CITY OF ALBUQUERQUE

**Re: Sunset Villa Subd Pond Recovery
Erosion and Sediment Control Plan
Engineer's Stamp Date 1-13-19 (K12E003_Hahn)**

Based upon the information provided in your submittal received 1-14-19, the above referenced plan is approved to be included in the SWPPP and for NOI documentation review with the following condition:

Erosion Sediment Control Plan

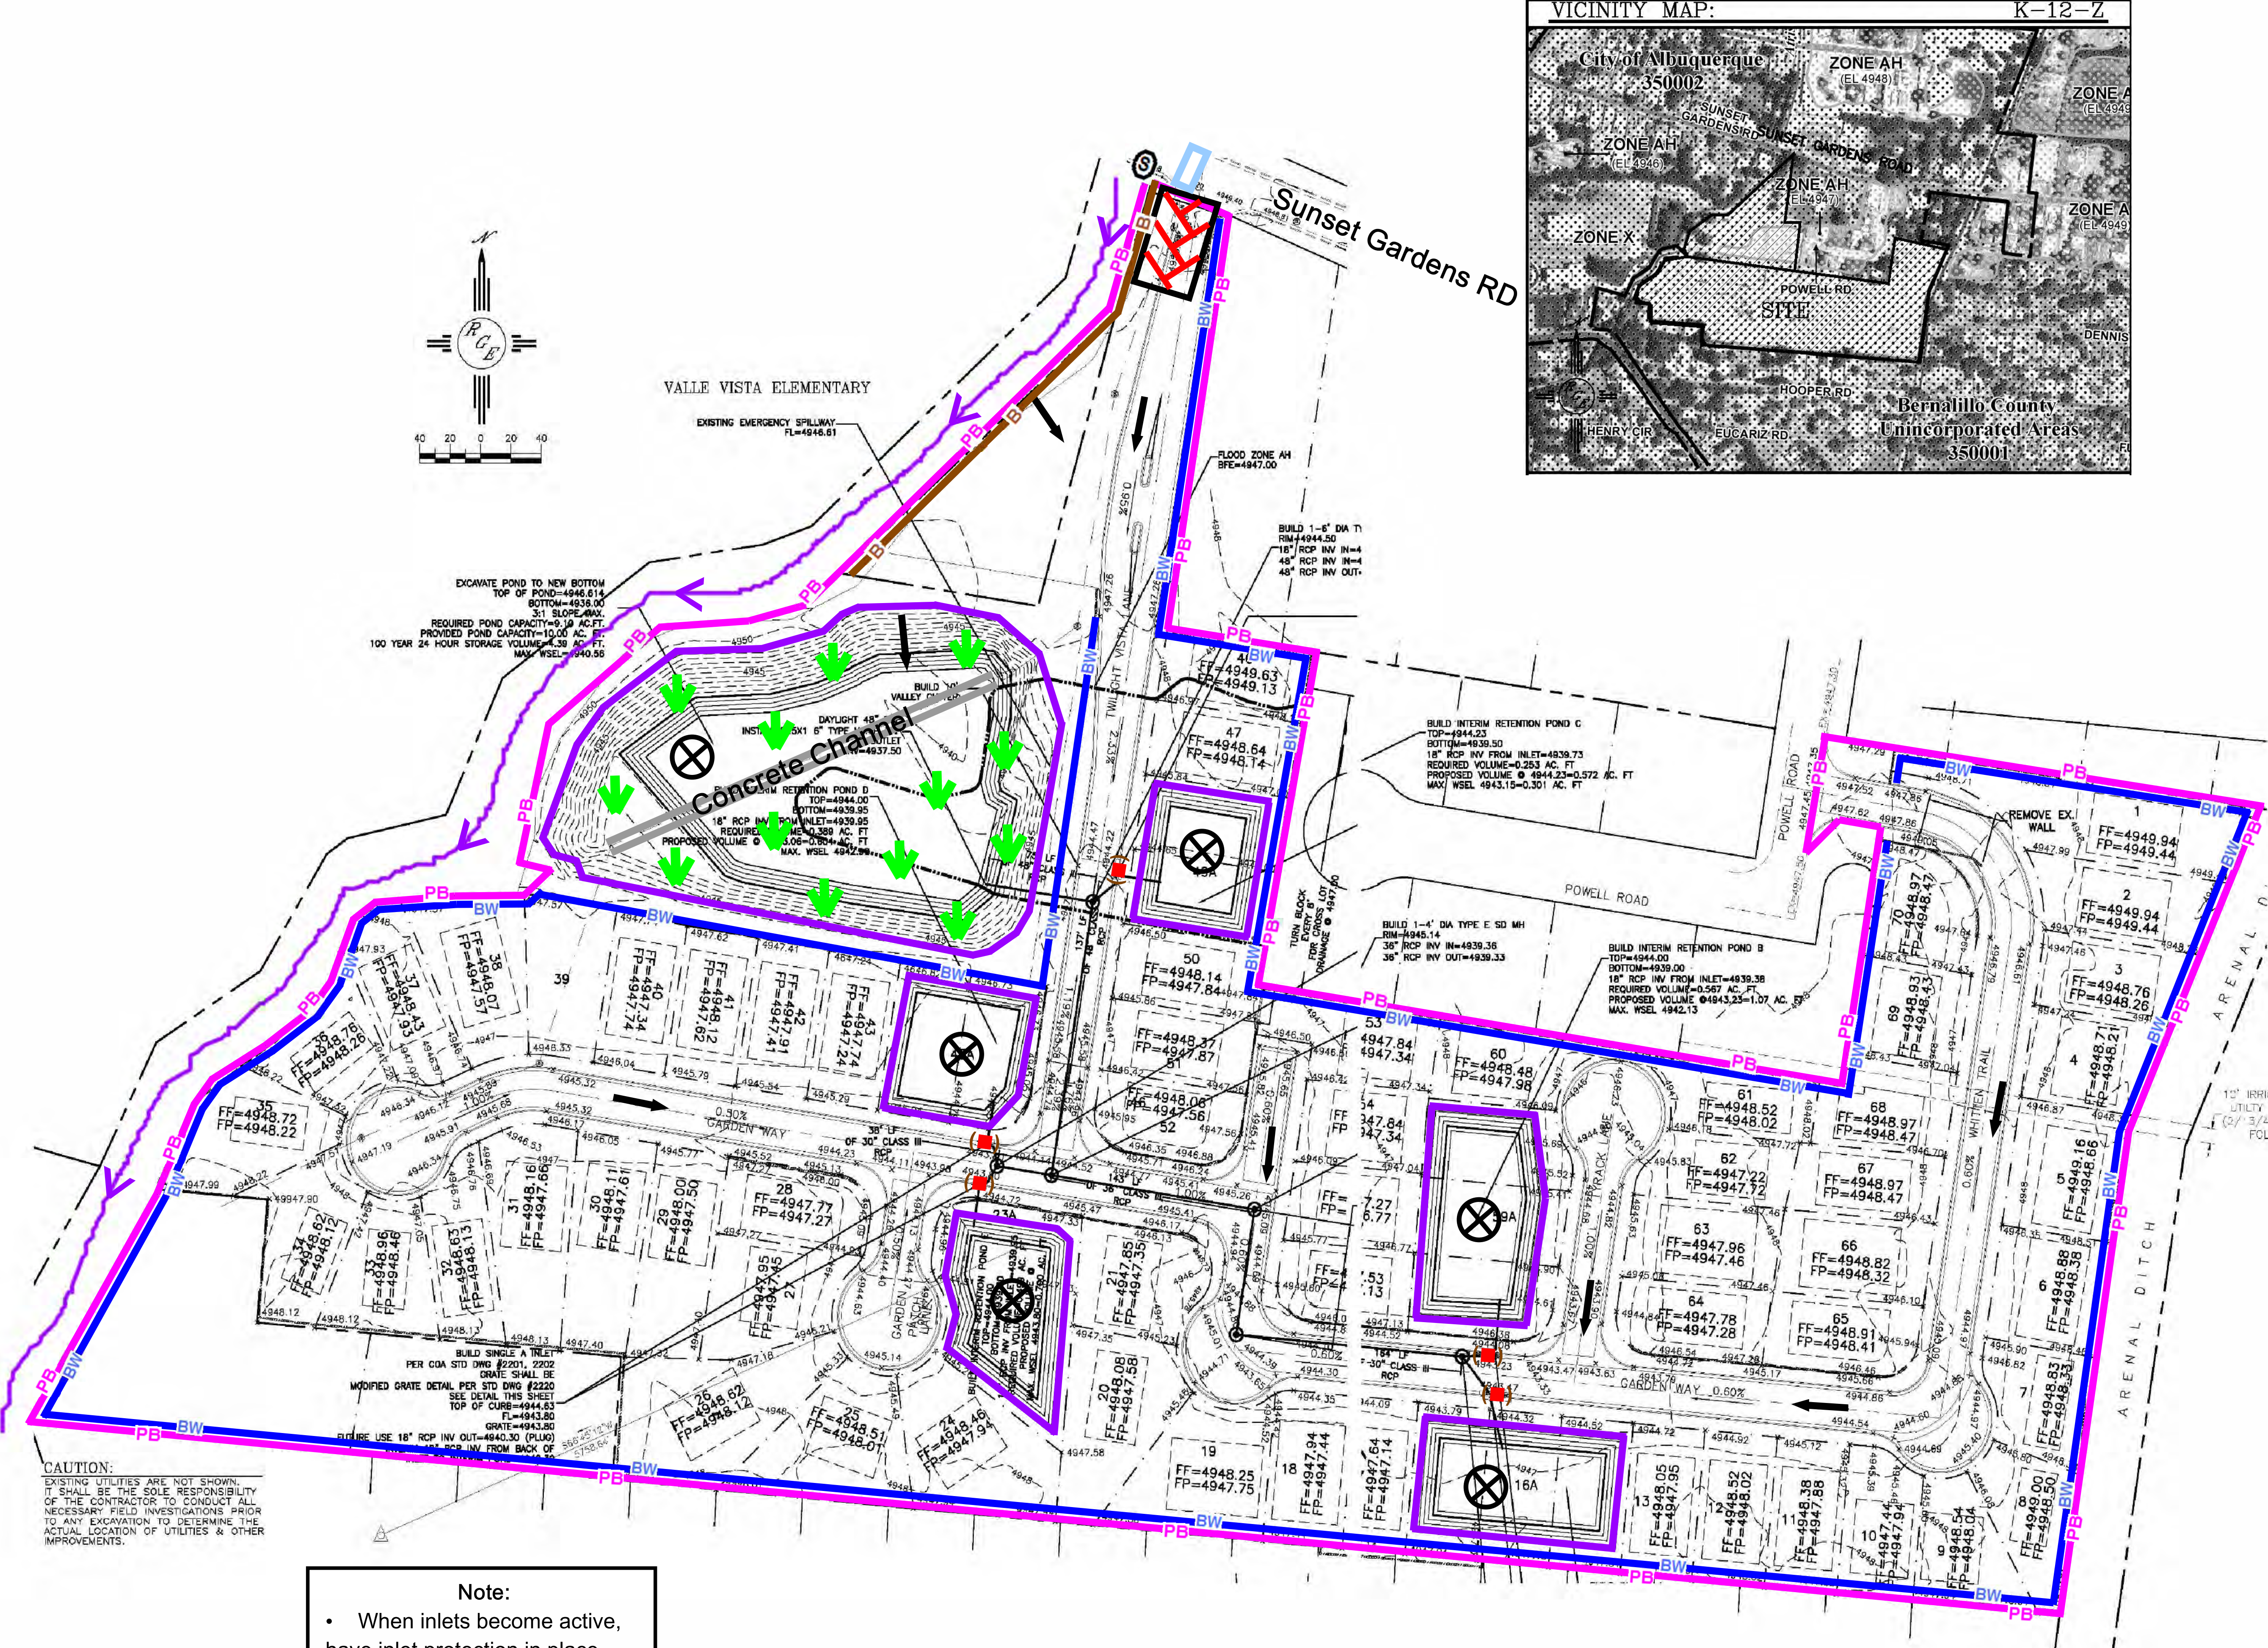
1. Lot 49A has silt fence where the large "X"s are shown.
